Engineers Comments Regarding Surface Water Drainage

Application Reference:	M/39/24/DOC	Reviewer Reference:	ADC/PC
Planning Officer:	Kathryn Welch	Date of Review:	21/01/2025
Site Name:	117 Elmer Road Middleton-on-Sea PO22 6LH		
Application Description:	Approval of details reserved by condition imposed under reference M/84/23/PL relating to condition number 7 - surface water drainage scheme.		
Assessment Number:	2 of 2

Application Reference: M/39/24/DOC Site Name: 117 Elmer Road Middleton-on-sea PO22 6LH	Initial Issue Date: 03/09/2024 Issue Date: 21/01/2025 Reviewer Reference: ADC/PC
---	--

Surface Water Drainage Comment Tracker

117 ELMER RD Soakaway Section

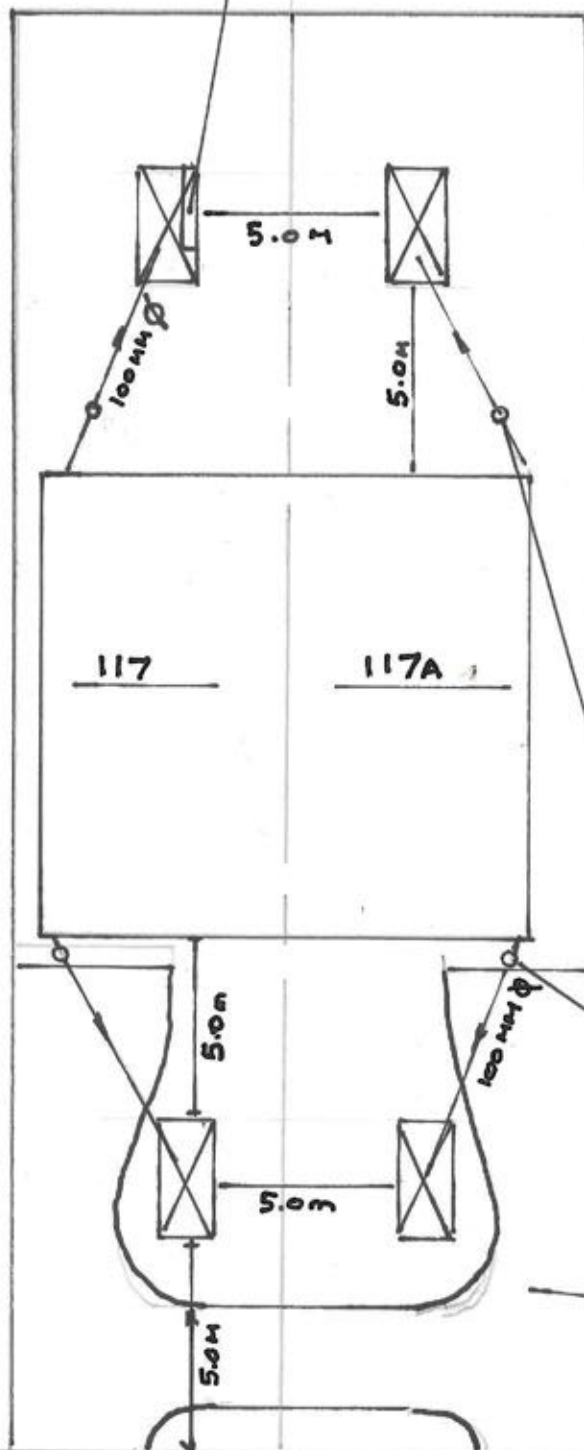
9.			The soakaways dimensions in the calculations do not reflect the soakaways that are proposed on the layout and section. Please submit revised calculations.	New design, point closed.

117 ELHERO Sockaway Section
 Sockaway size 3.0m x 1.8m x 0.84m

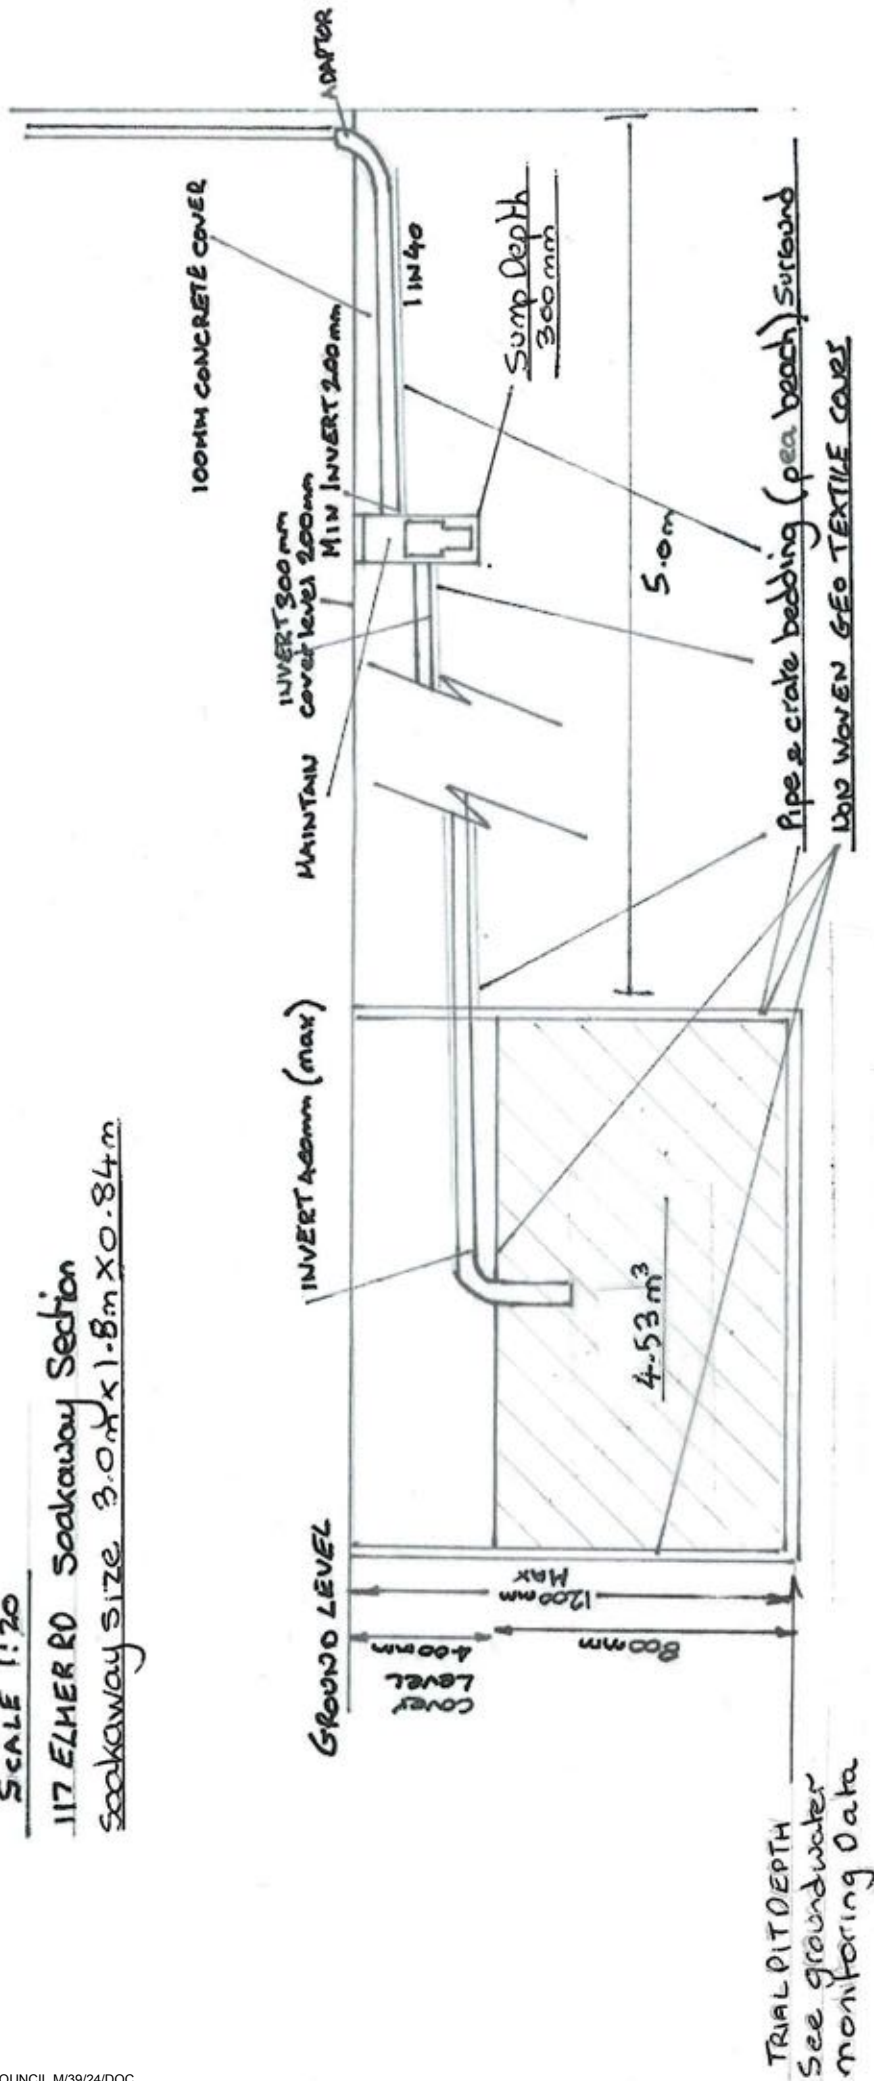
10.			Please stipulate the gradient of the pipe between the silt trap and the soakaway on the soakaway section drawing	Gradients provided. Pipe upstream of SWM1 does not include gradient and is likely steeper than 1 in 100 as described by the notes.

as the current drawing assumes level ground. If the ground is not level, then basing the design drawings only on dimensions below ground level can risk an inadequate gradient and siltation of the pipes.		
11.			The cover level of the soakaway is likely to be more than 400mm to achieve a 1 in 40 gradient for the length of pipe proposed. Please adjust the design as necessary.	New design. Point closed.	
12.			Please provide full construction details for the silt traps.	Point closed.	
13.			Please specify the distance of the vertical pipe drop into the soakaway (from the top of the soakaway to the top of the pipe. [An alternative option is to have the incoming pipe at the side of the soakaway into one of the likely prefabricated inlets. This will aid the designer in achieving the specified gradients without altering the depth of the soakaway.]	New design. Point closed.

15.			Please specify that the non-woven geotextile is <u>permeable</u> and make it clear on the soakaway section that this is a full wrap, not just cover.	Please also label the membrane below the tarmacadam on the permeable paving detail.

20.				Suggested: include dimensions of the soakaways rather than just plan areas.	
21.				Soakaways must be set at 1.2m below ground level to accord with the infiltration testing (see point 1). Therefore, the soakaways must be set deeper.

22.				Soakaway base levels appear to not be consistent between the construction details and the layout. It is assumed that the IL labelled directly next to the soakaways relate to the incoming pipe invert levels . Please clarify. It is suggested that the incoming pipe invert level, or the base of the soakaway are labelled with different notation on the layout to avoid confusion.

SURFACE WATER DRAINAGE PLAN
117 ELMER RD
SCALE 1:200

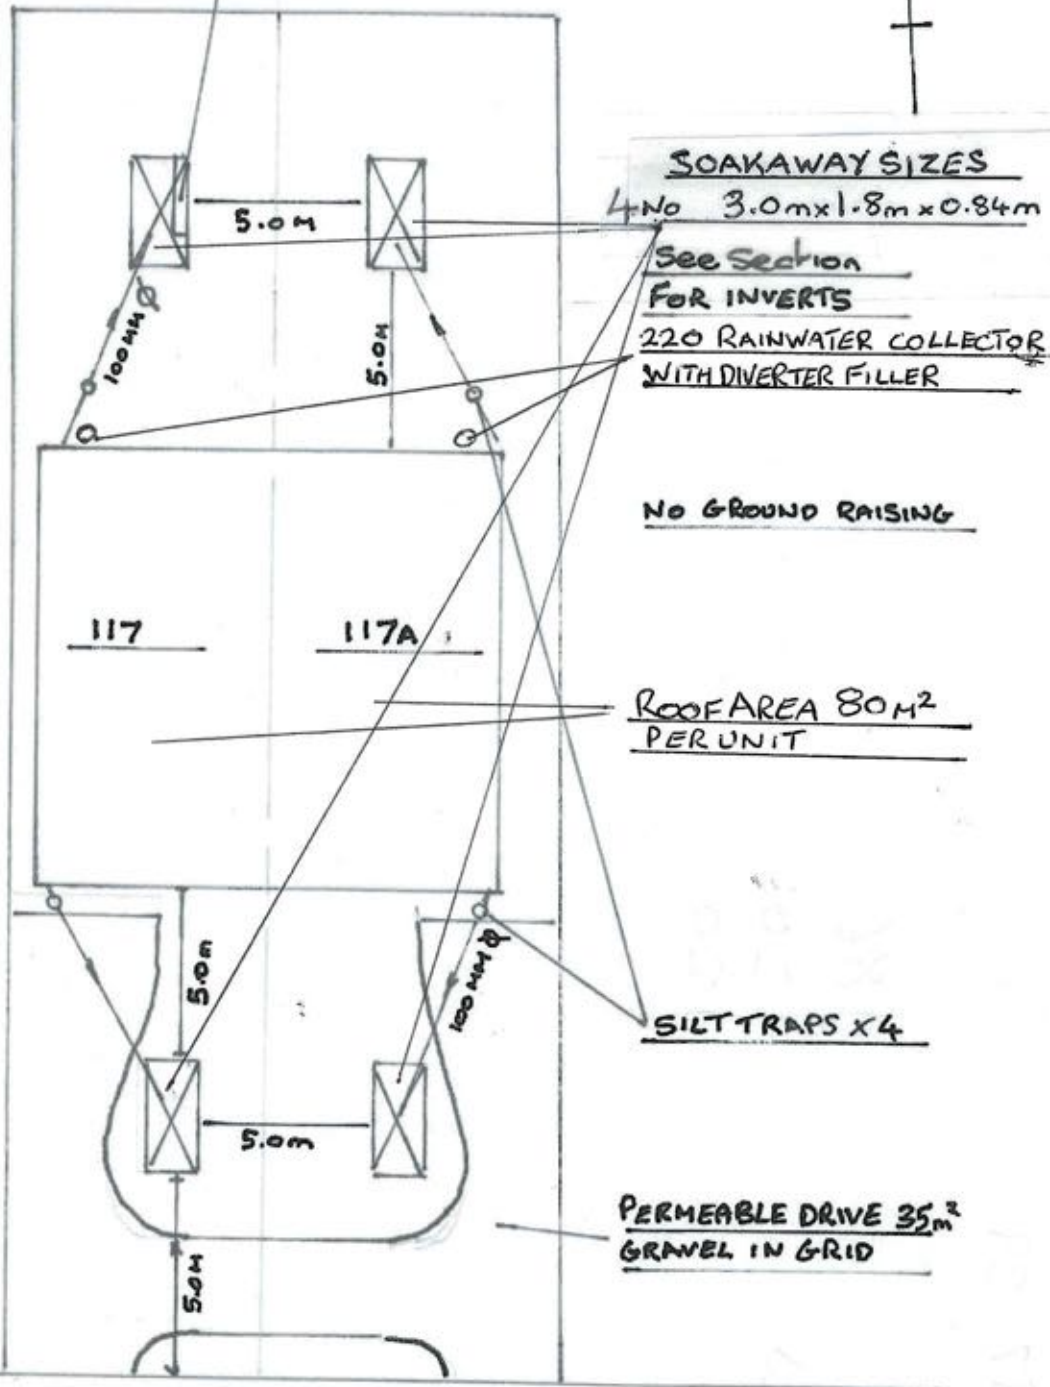
one at the front and one at the rear).				
3.	The soakaways at the front of the proposed properties are positioned too close together, ideally these should be 5m apart.	Thank you – described in method but not shown clearly on the layout. Please mark.	Thank you – point closed.

4.	Please provide catchpits/silt traps upstream of all soakaways.	Thank you – point closed.			
5.	The drainage layout requires further detail. Please see guidance note k on the attached drainage checklist for the level of detail required.	Soakaways need to be labelled with base levels and cover levels. Silt traps (which will also be inspection chambers) need to be labelled with cover levels and pipe invert levels. The invert level of '300' given for the soakaways is unclear if it relates to the incoming pipe invert level – which we need, or the base of the soakaway. It is unclear what the 300 relates to, mm below ground level?	Please see points 10 and 11 below regarding 'levels' vs 'depths below ground level' and the risk involved with this descriptor.	Please see comments 14, 17, 19, 20-23 below.

7.	Please ensure that your drainage layout clearly indicates that soakaways are positioned 5m from the proposed properties.	Thank you – point closed.

17.				Why is there no rodding eye or inspection chamber north of proposed 117a at the junction of the RWP? Upstream of SWM1.	
18.				The design has changed to two (rather than 4) soakaways. These are in the centre of the

divided front and rear gardens. How will management and maintenance be organised between the future homeowners?	
19.				Please provide a plan and details showing how that the new design for the rear soakaways will not be structurally impacted by boundary treatments – particularly in the rear gardens.
